From: Anne Robinson [REDACTED]
Sent: 16 July 2021 08:09
To: A57 Link Roads <A57LinkRoads@planninginspectorate.gov.uk>
Subject: TR010034 Development Consent Order (DCO) for the proposed A57 Link previously Trans Pennine Upgrade Programme (TPUP)

TR010034 Development Consent Order (DCO) for the proposed A57 Link previously Trans Pennine Upgrade Programme (TPUP)

We would be most grateful for your advice regarding due process concerning what we believe are omissions from the above DCO application and an inadequate appraisal undertaken by Highways England for the A57 Link Roads.

Drawing Title: **FIGURE 15.1 COMMITTED DEVELOPMENTS**

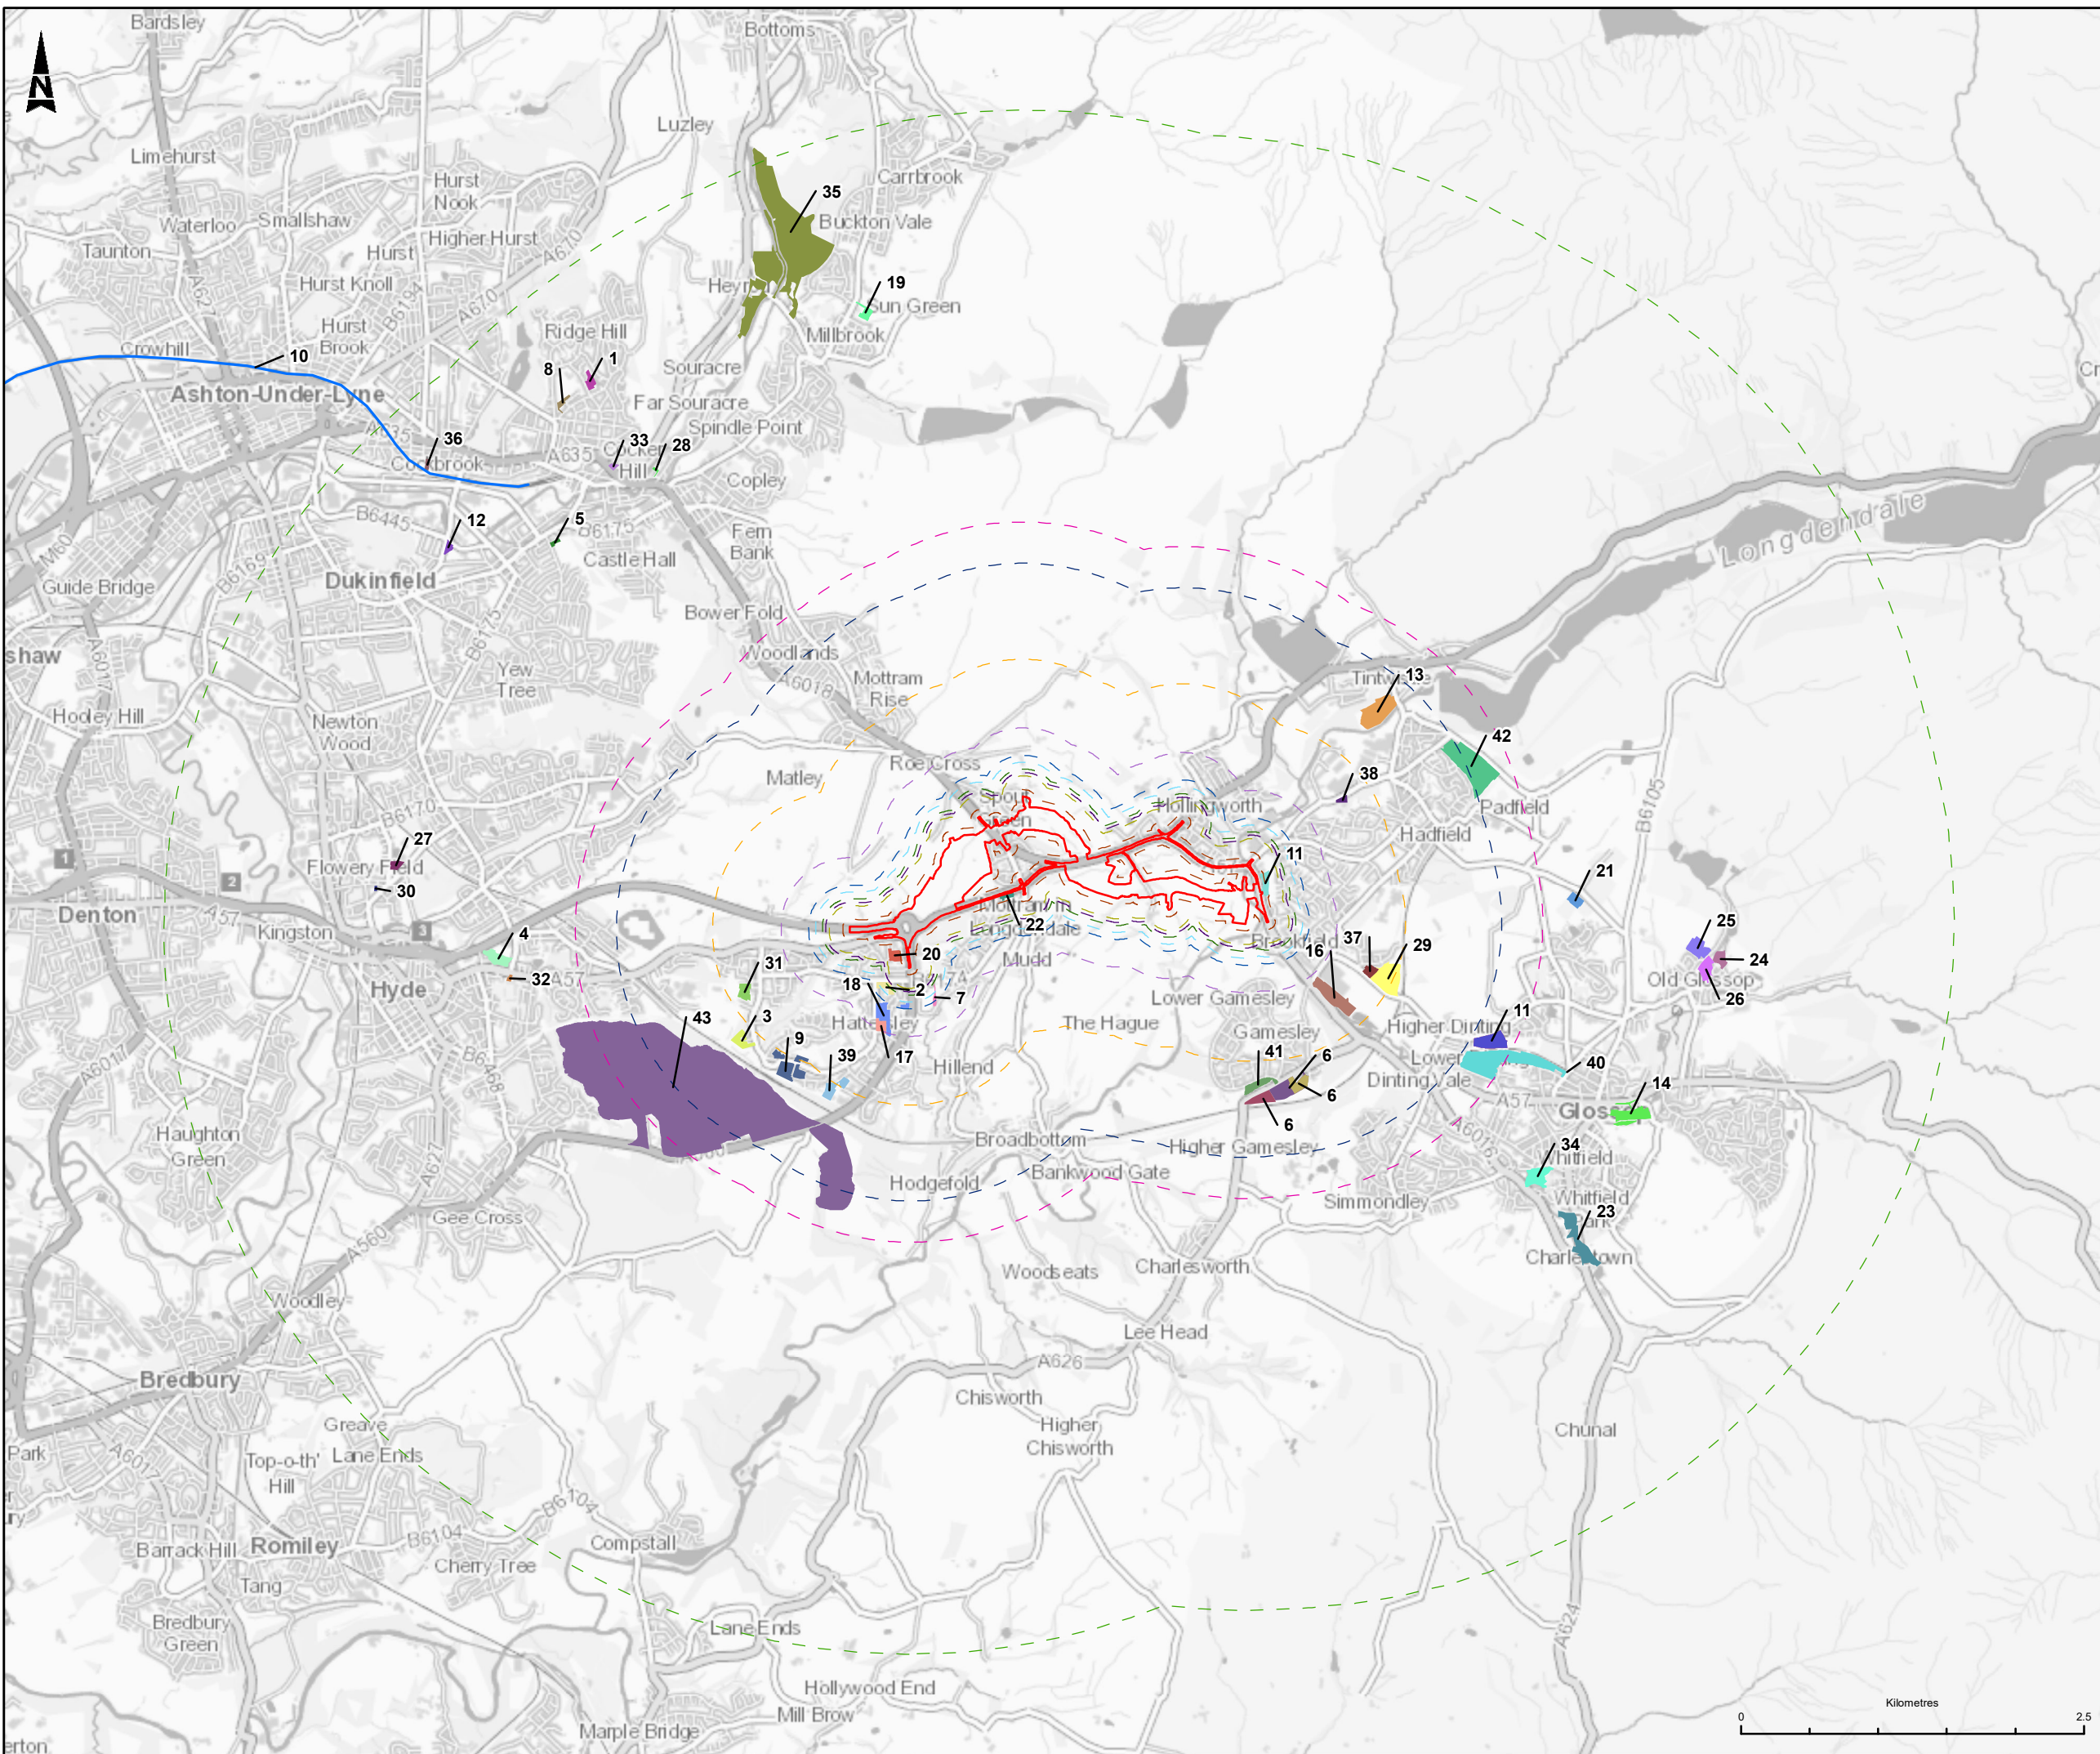
Developments in Barnsley and Sheffield that could impact on trans-Pennine roads do not appear to have been considered in the ES Chapter 15 Cumulative Impacts. As one of the objectives of the scheme is to increase connectivity between Manchester and Sheffield, and traffic flows on trans-Pennine routes increase we believe consideration of developments in these areas should have been included.

There is also no mention in ES Chapter 15 of another major development, the Hollingworth-Tintwistle bypass. This is identified in the Sheffield City Regional Mayoral Combined Authority's Roads Implementation Plan to be delivered between 2019 and 2024; in Greater Manchester's Transport Strategy 2040 para 277 as an intervention by 2025 to alleviate the issues at Hollingworth and Tintwistle; and in Transport for the North's Investment Programme Table 3 as at Project Control Framework Stage 1 and a specific intervention before 2027. The Hollingworth-Tintwistle bypass therefore appears to fulfil the criteria for consideration as it is a Tier 3 scheme as defined in PINS advice Note 17 on Cumulative Impacts Assessment, version 2, 2019. Evidence of this consideration should therefore be included.
